**Martin Place North Site Stage 2 (SSD-9270)
Conditions B5 and B6 - design changes request**

Attachment A – Changes determined to not require review by the DRP

Level 08 Plan

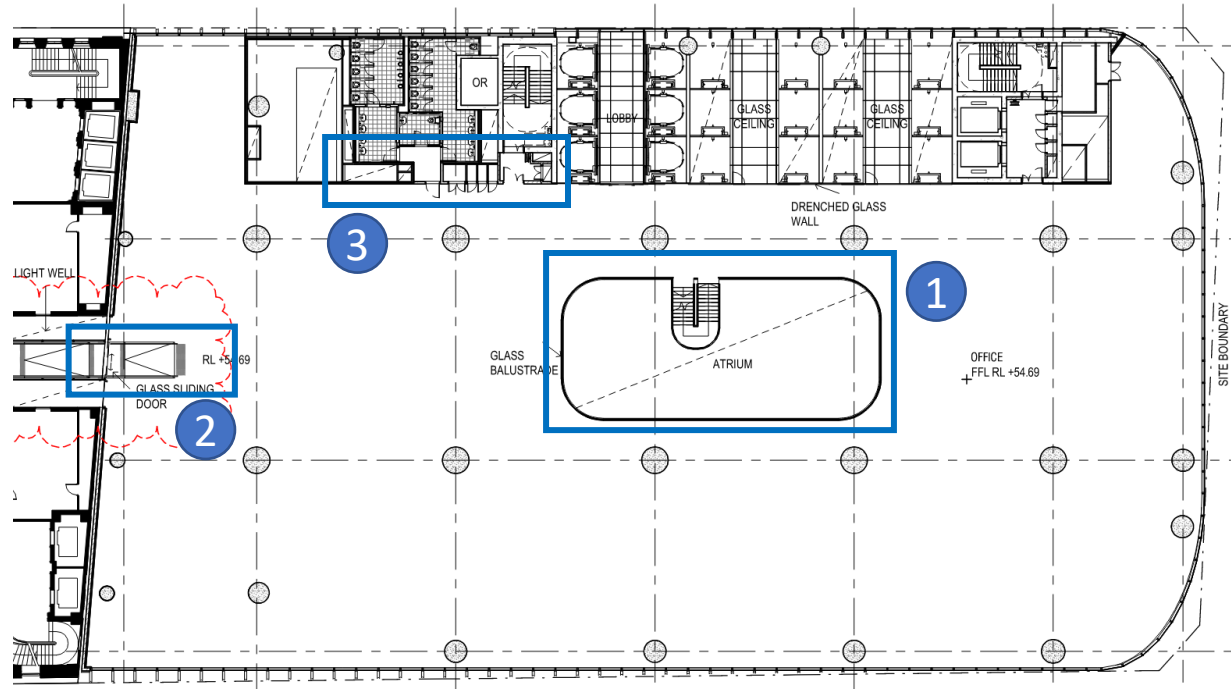
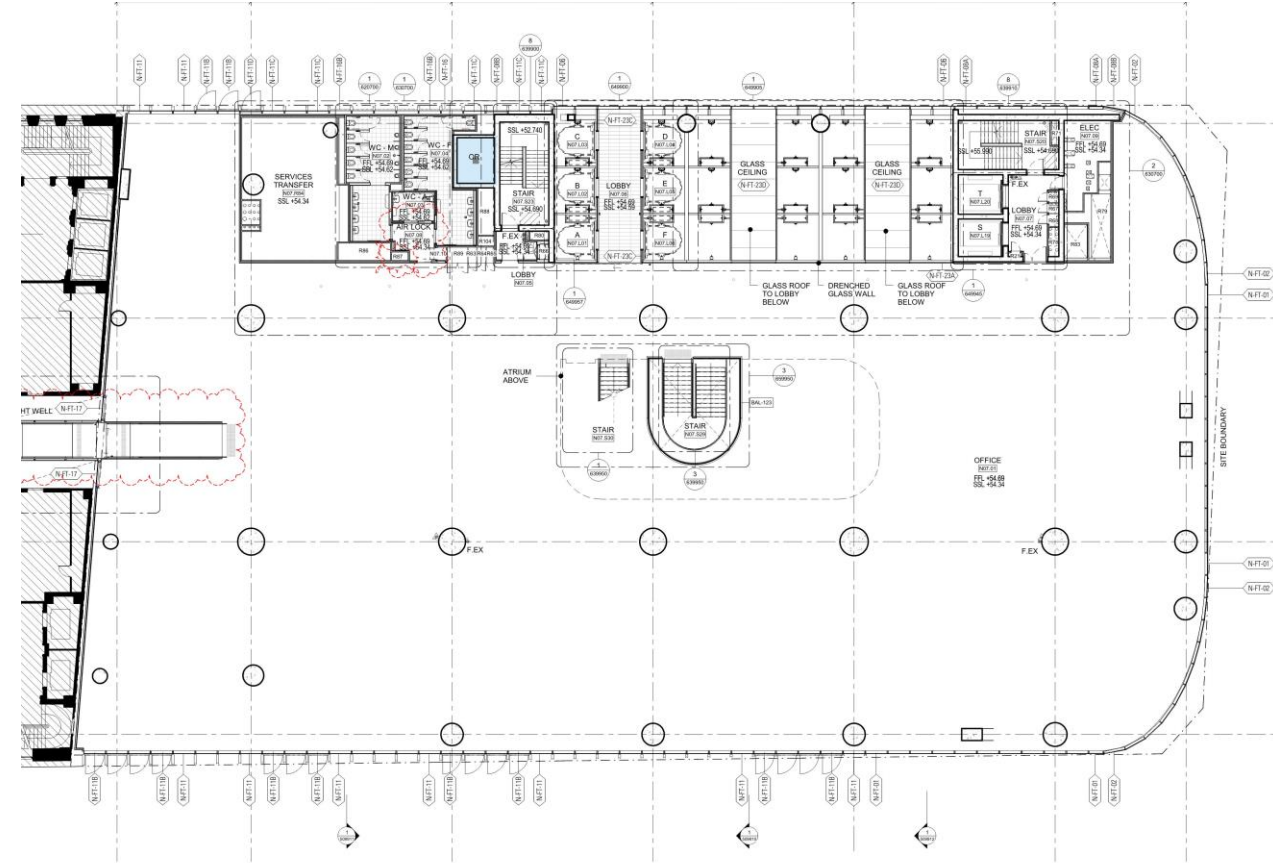
Design Change
Level 7 - revised position and design of inter-tenancy stair and atrium - revised back-of-house design (amenities and services risers) - revised internal ramp leading to Level 8 bridge structure above
Level 8 - revised position and design of inter-tenancy stair - revised back-of-house design (amenities and services risers) - revised internal ramp leading to bridge structure
Level 9 - revised position and design of inter-tenancy stair - revised back-of-house design (amenities and services risers)
Level 10 - revised position of inter-tenancy atrium and stair - increase balustrade height from 1375mm to 1800mm and change handrail to frameless glazing along outdoor breakout spaces/terraces - revised back-of-house design (amenities and services risers) - sliding door to outdoor terrace replaced with revolving door
Level 11 - additional internal atrium void at southern end adjacent to Level 10 terrace below - revised position of inter-tenancy atrium and stair

Lower Roof Plan

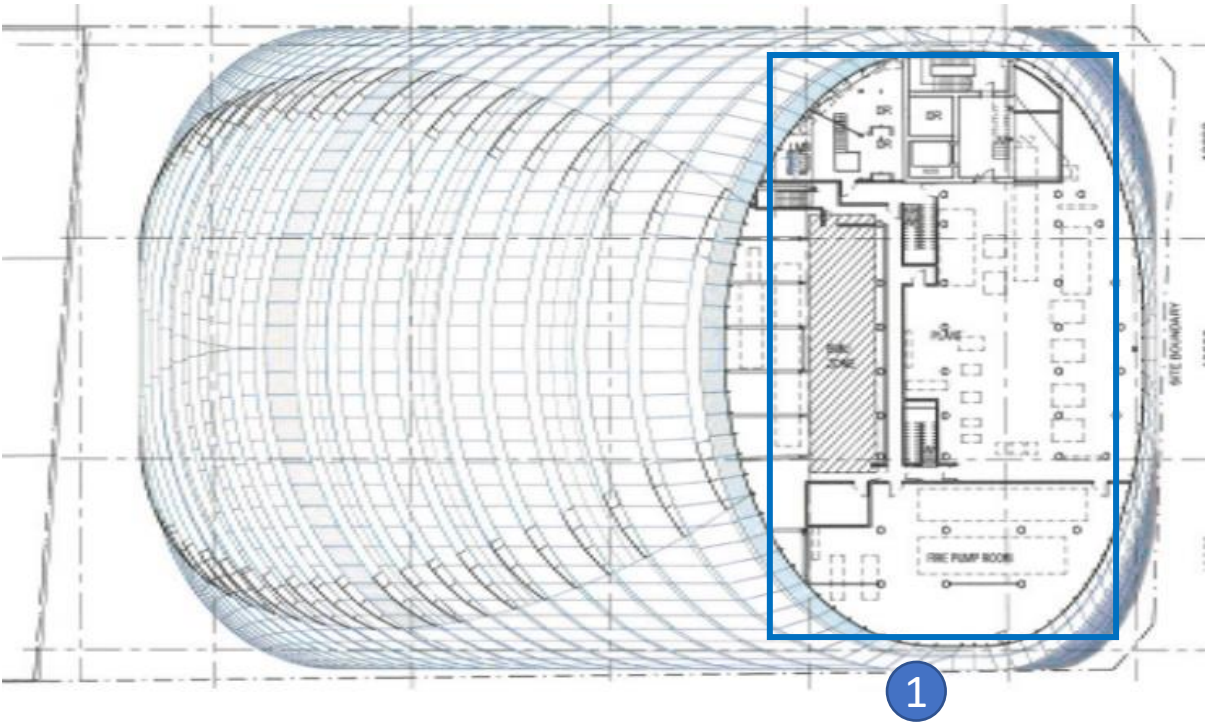
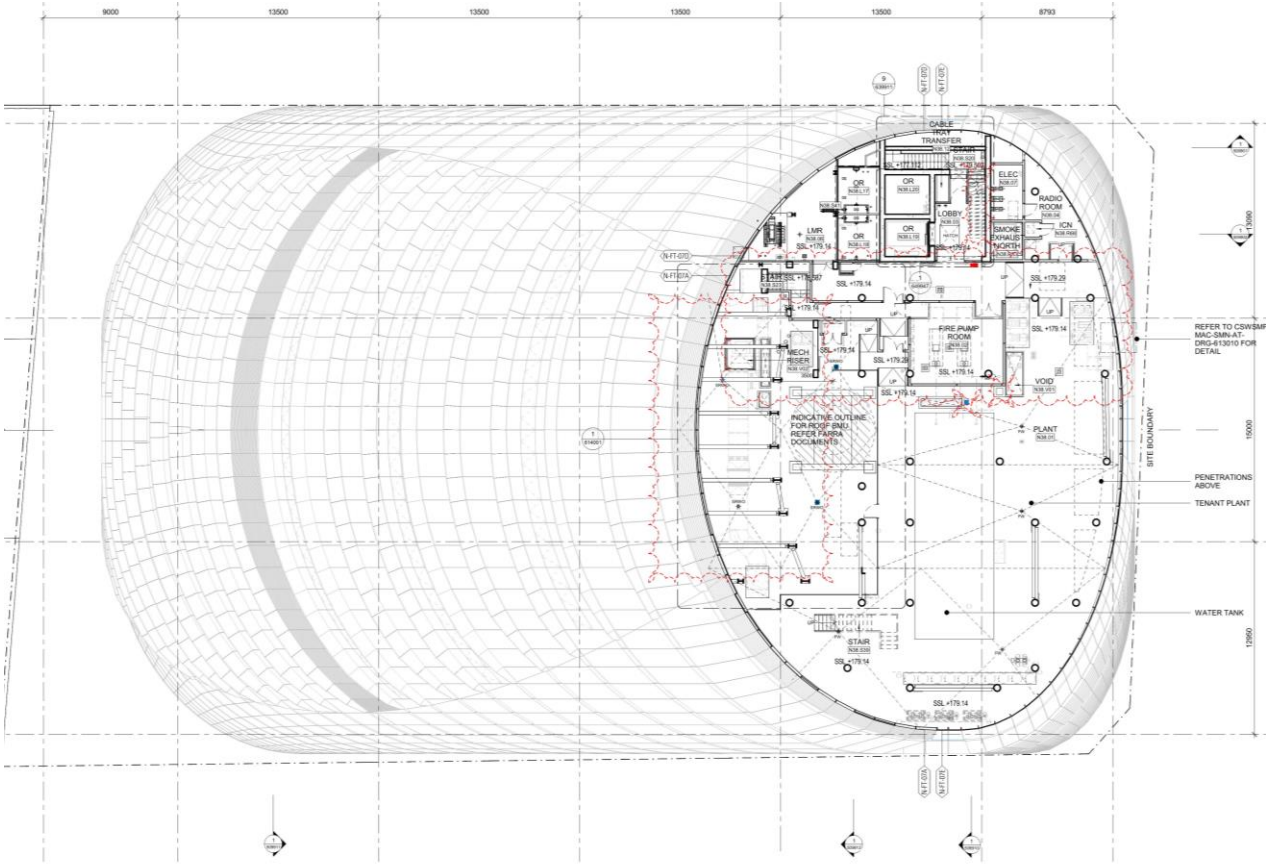
Level 12-14 - revised position of inter-tenancy stair - revised back-of-house design (amenities and services risers)
Level 15 revised internal services riser and plantroom
Level 16 - removal of inter-tenancy stair - revised back-of-house design (amenities and services risers)
Levels 17-27 - revised inter-tenancy stair - revised back-of-house design (amenities and services risers)
Level 28 revised internal plant room configuration
Levels 29-34 - revised back-of-house design (amenities) - deletion of internal columns at south end of tenancy
Levels 35-37 - revised back-of-house design (amenities) - revised internal fire stair reconfiguration
Lower Roof revised internal plant room configuration
Upper Roof - revised internal plant room configuration - reduced size of access hatch for building maintenance

East Elevation

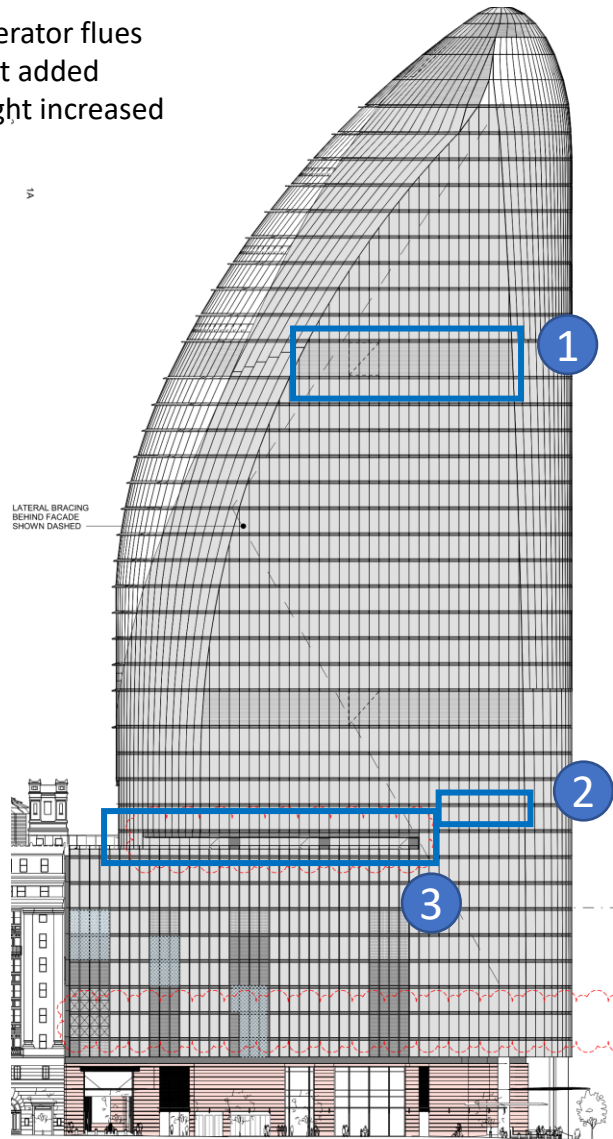
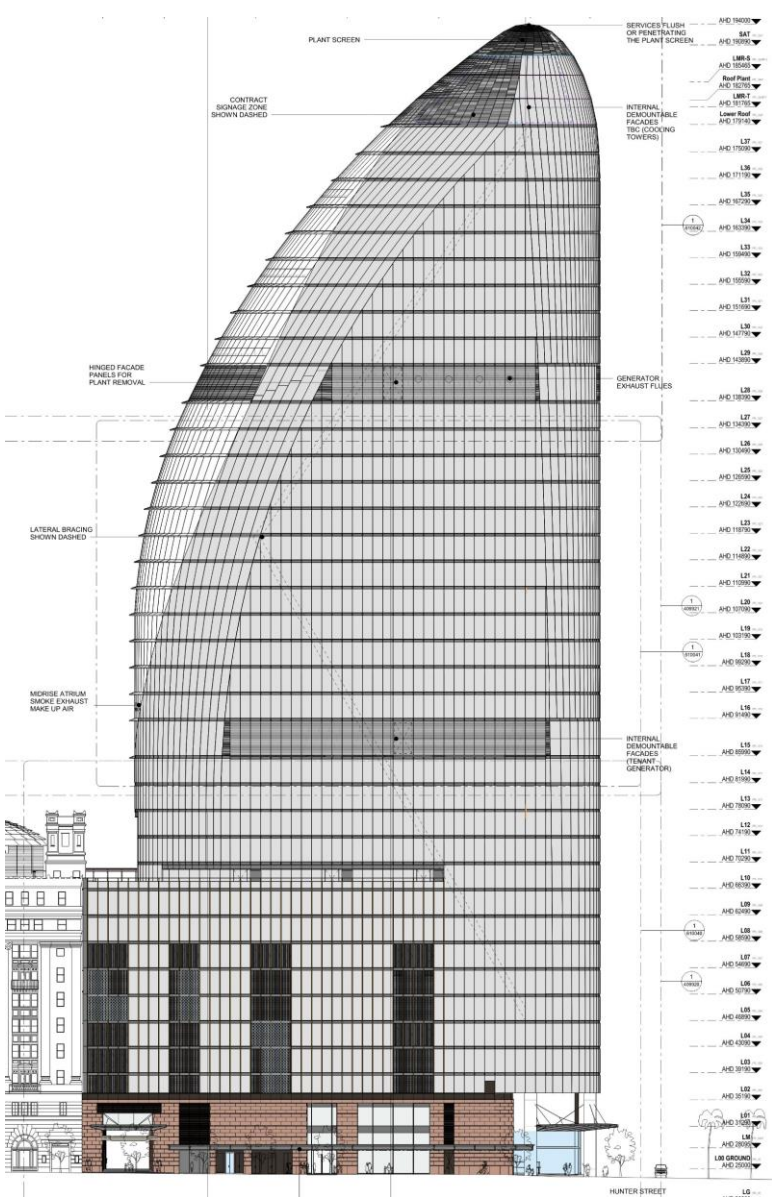
East elevation

- additional generator flues behind metal screening finish
- added kitchen exhaust integrated with window spandrel panels
